Jeanie Bourke - FW: The Inn at Diamond Cove - permit review

From: Barry Yudaken [mailto:yudaken@archetypepa.com]
Sent: Monday, April 15, 2013 12:06 PM
To: David Lloyd; Susan Geffers
Subject: The Inn at Diamond Cove - permit review

CBL: 083E E4600 **Permit ID:** 2013-00436

4/10/2013-JMB/Building:

B RAILING DETAILS AT PORCHES
SCALE: 1"=1'-0"

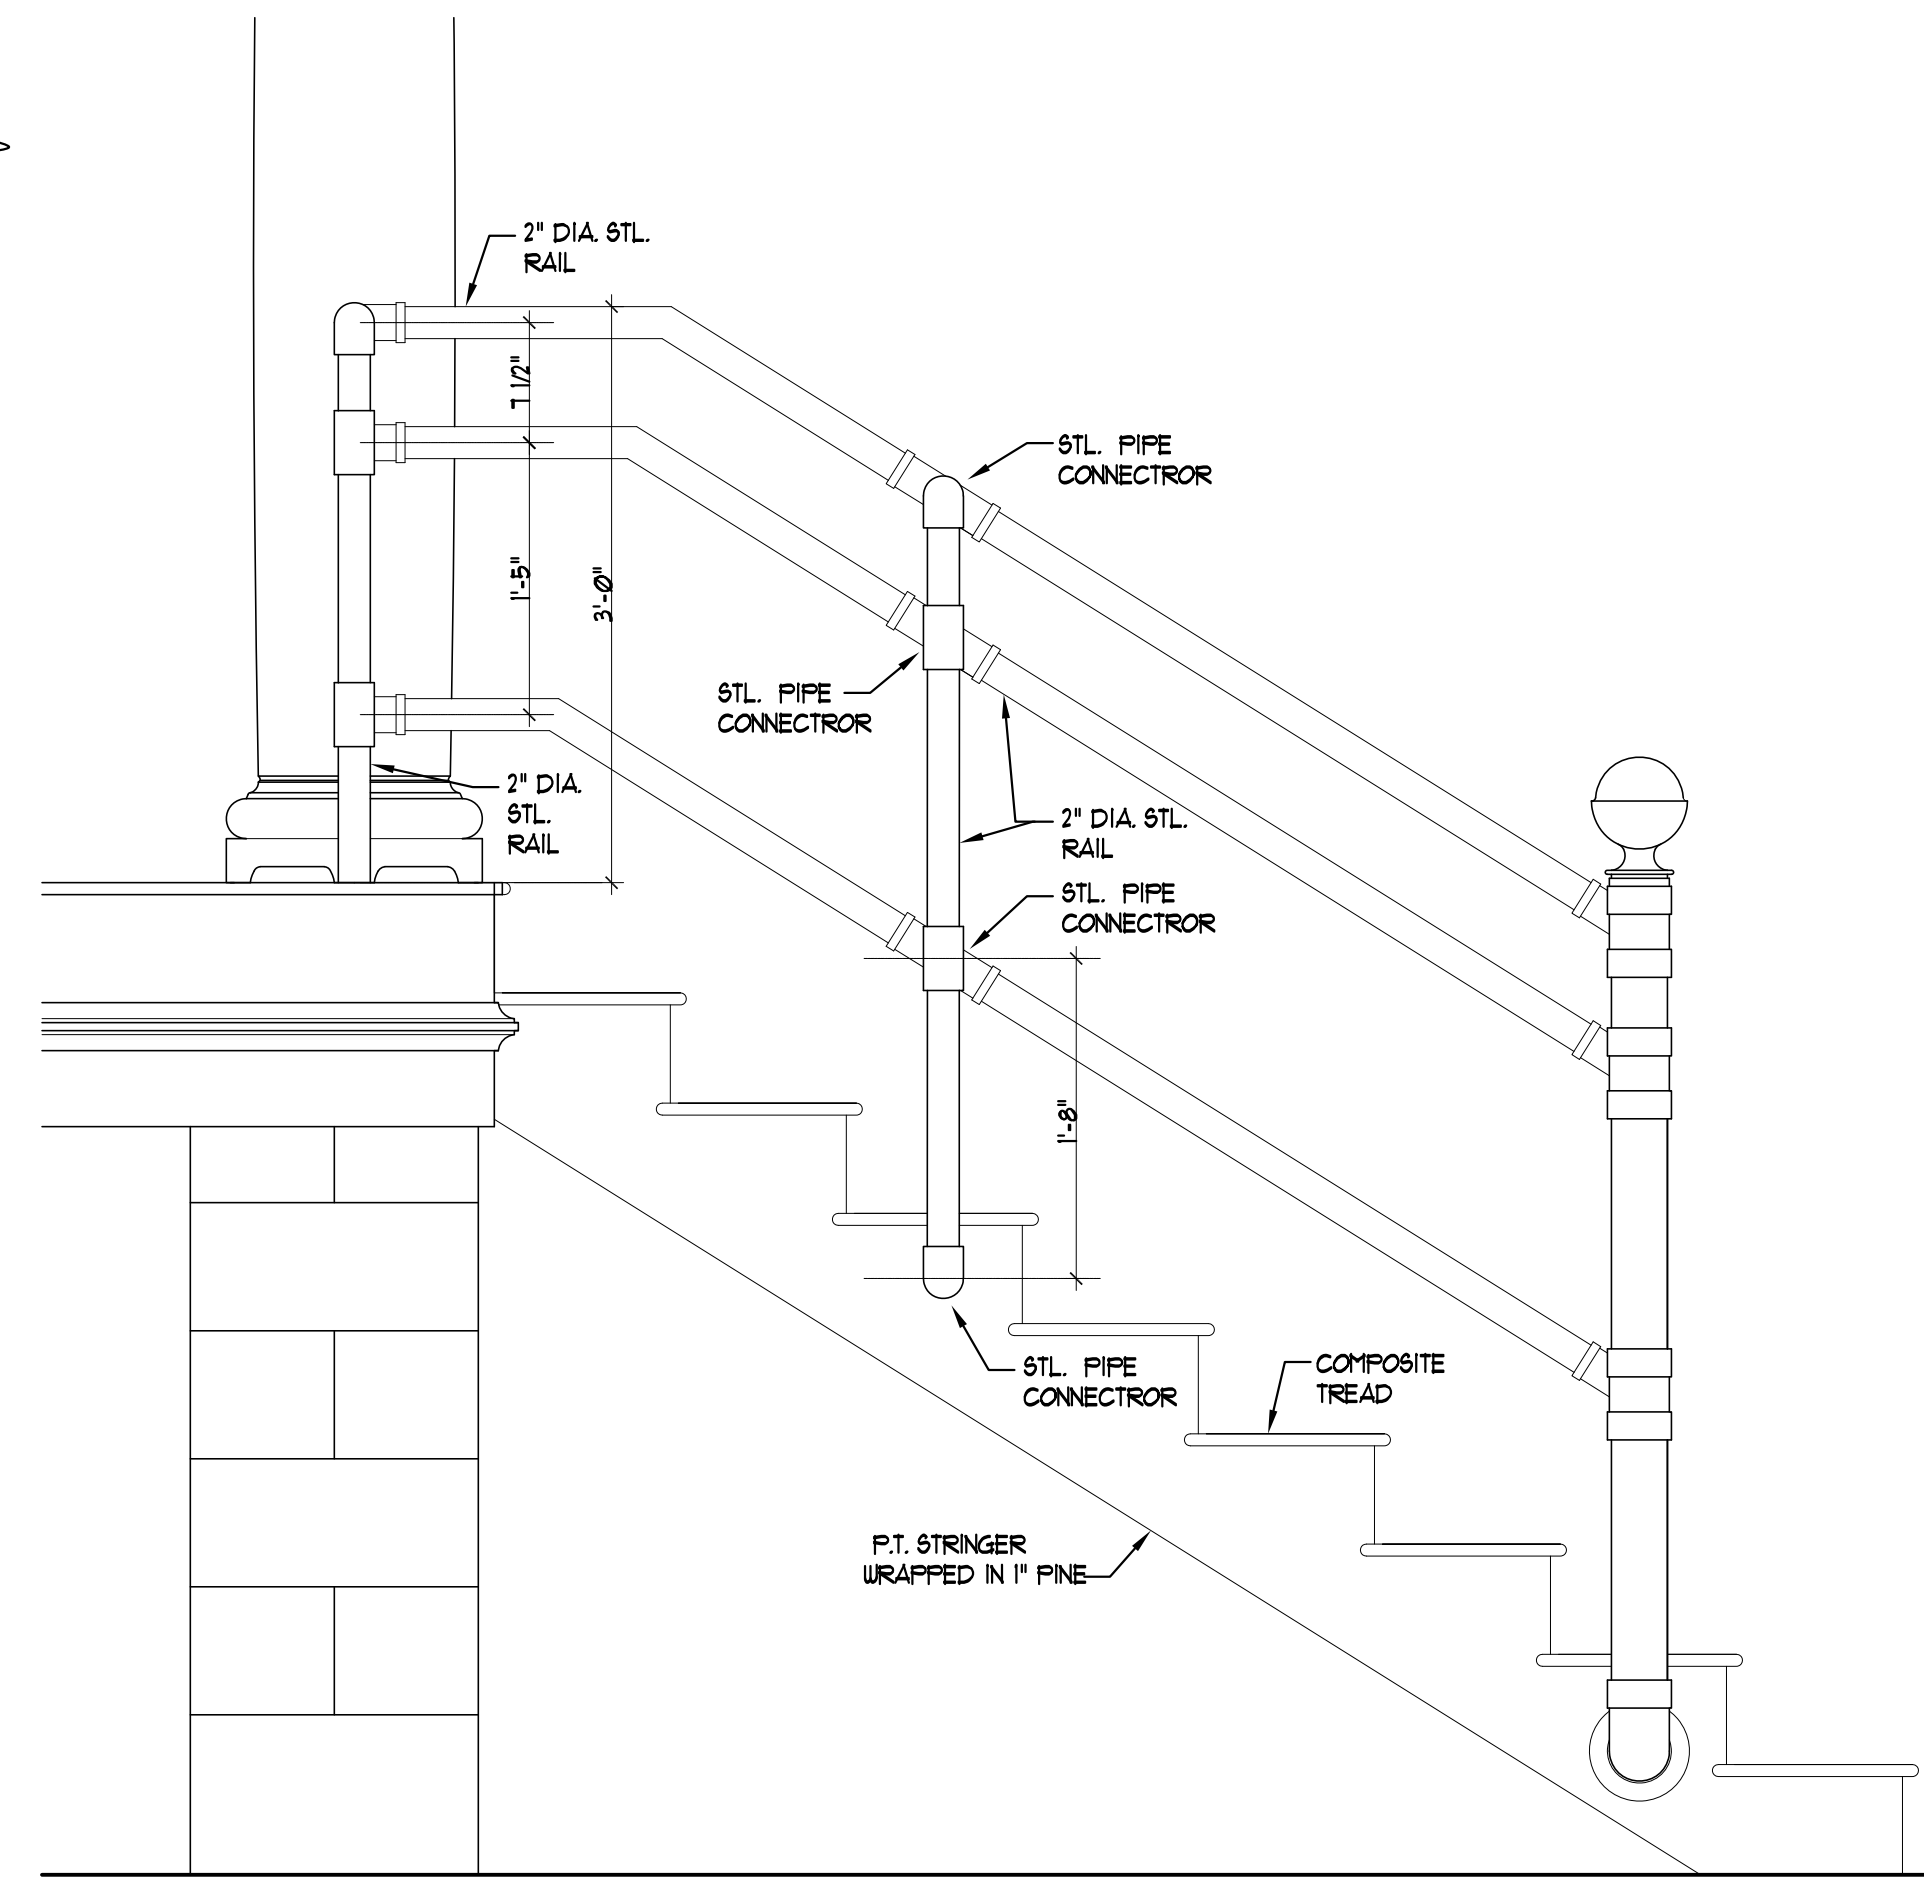
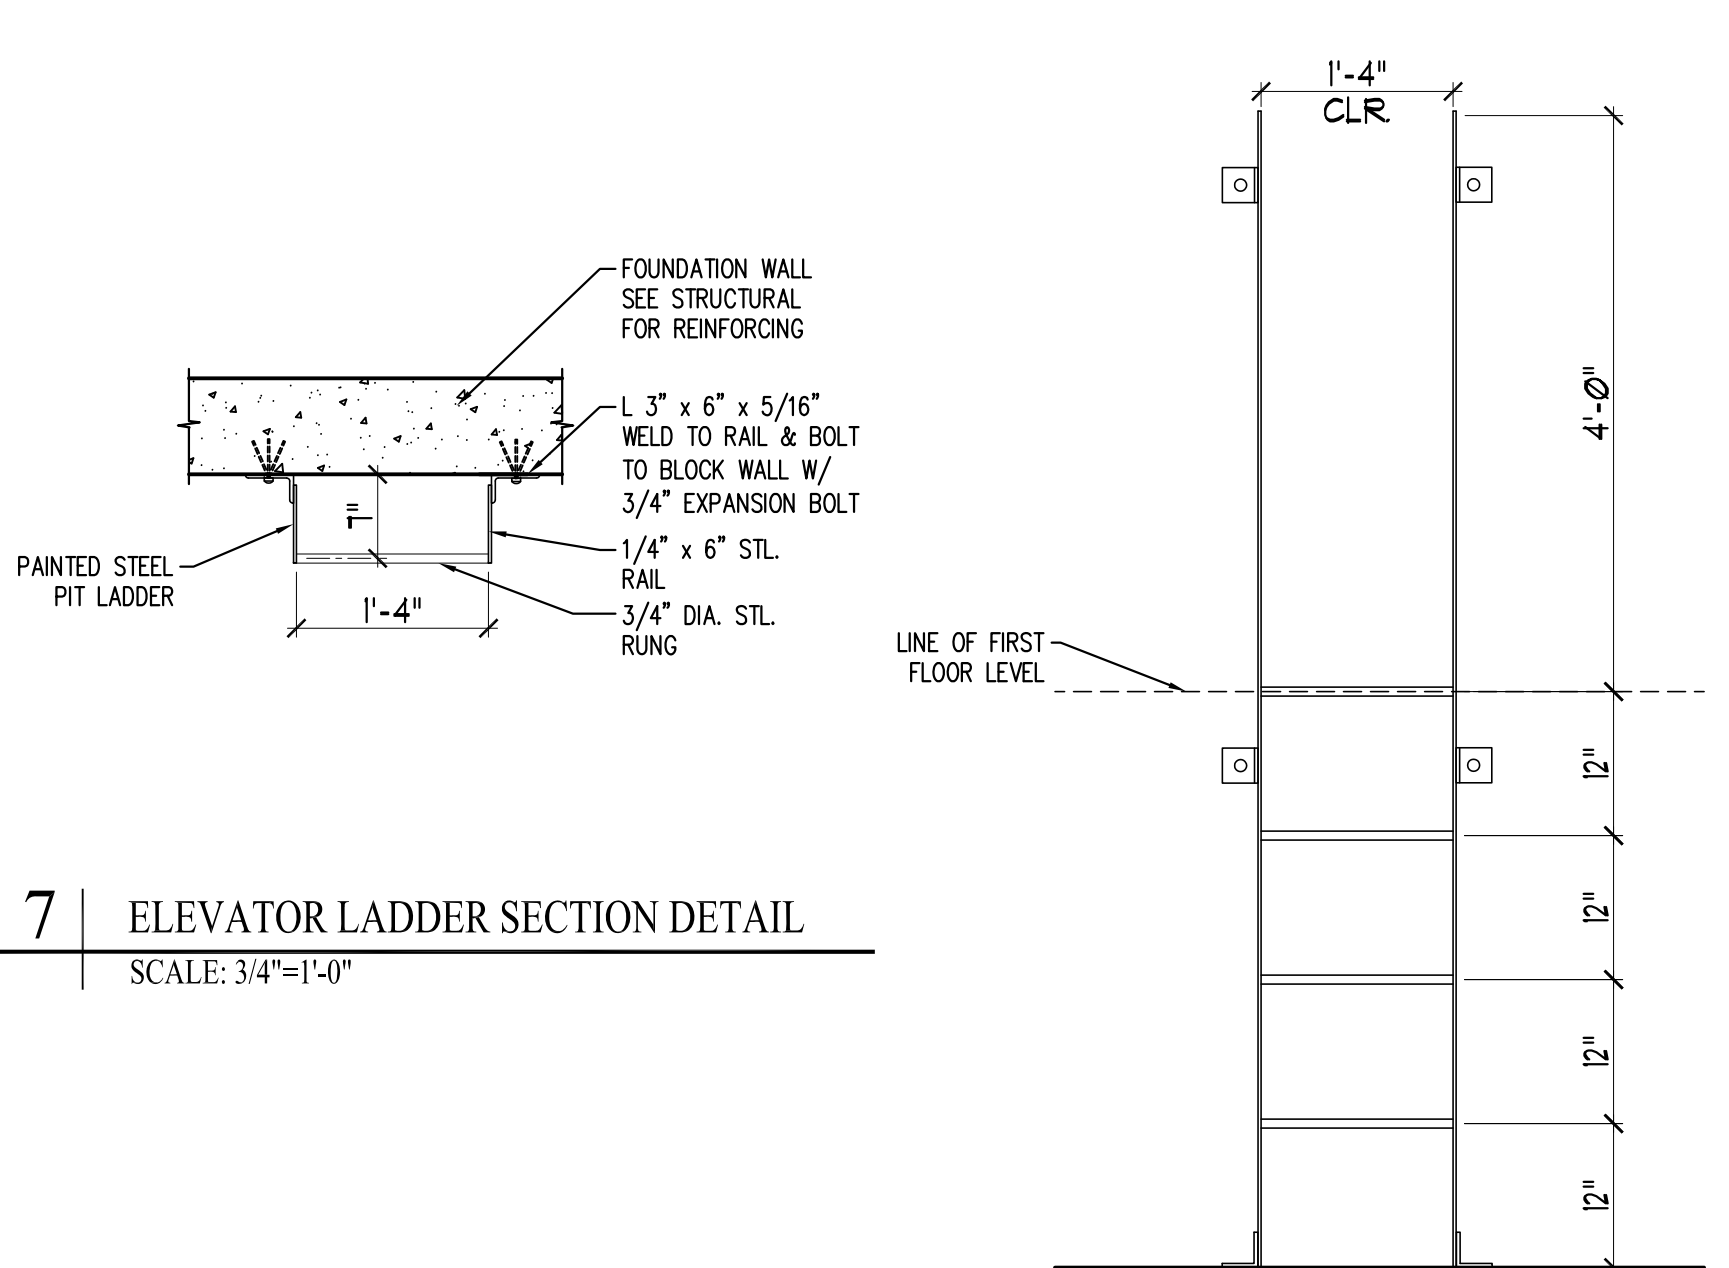
7. Plan A3.11 - Justify exterior pipe rail compliance deviation of code requirements for the opening limitations & height **Section 3409 Historic Buildings . This project is a designated historic landmark being rebuilt under the requirements of the National Park Service. Also all railings approved by Portland HP board we hope to receive**

your blessing that these railings do not constitute a distinct life safety.

14. Provide exterior stair section and dimensional details **see revised stair section drawing A3.11**
15. Are plumbing and mechanical plans completed, at least schematics? **We do not have these at this time.**
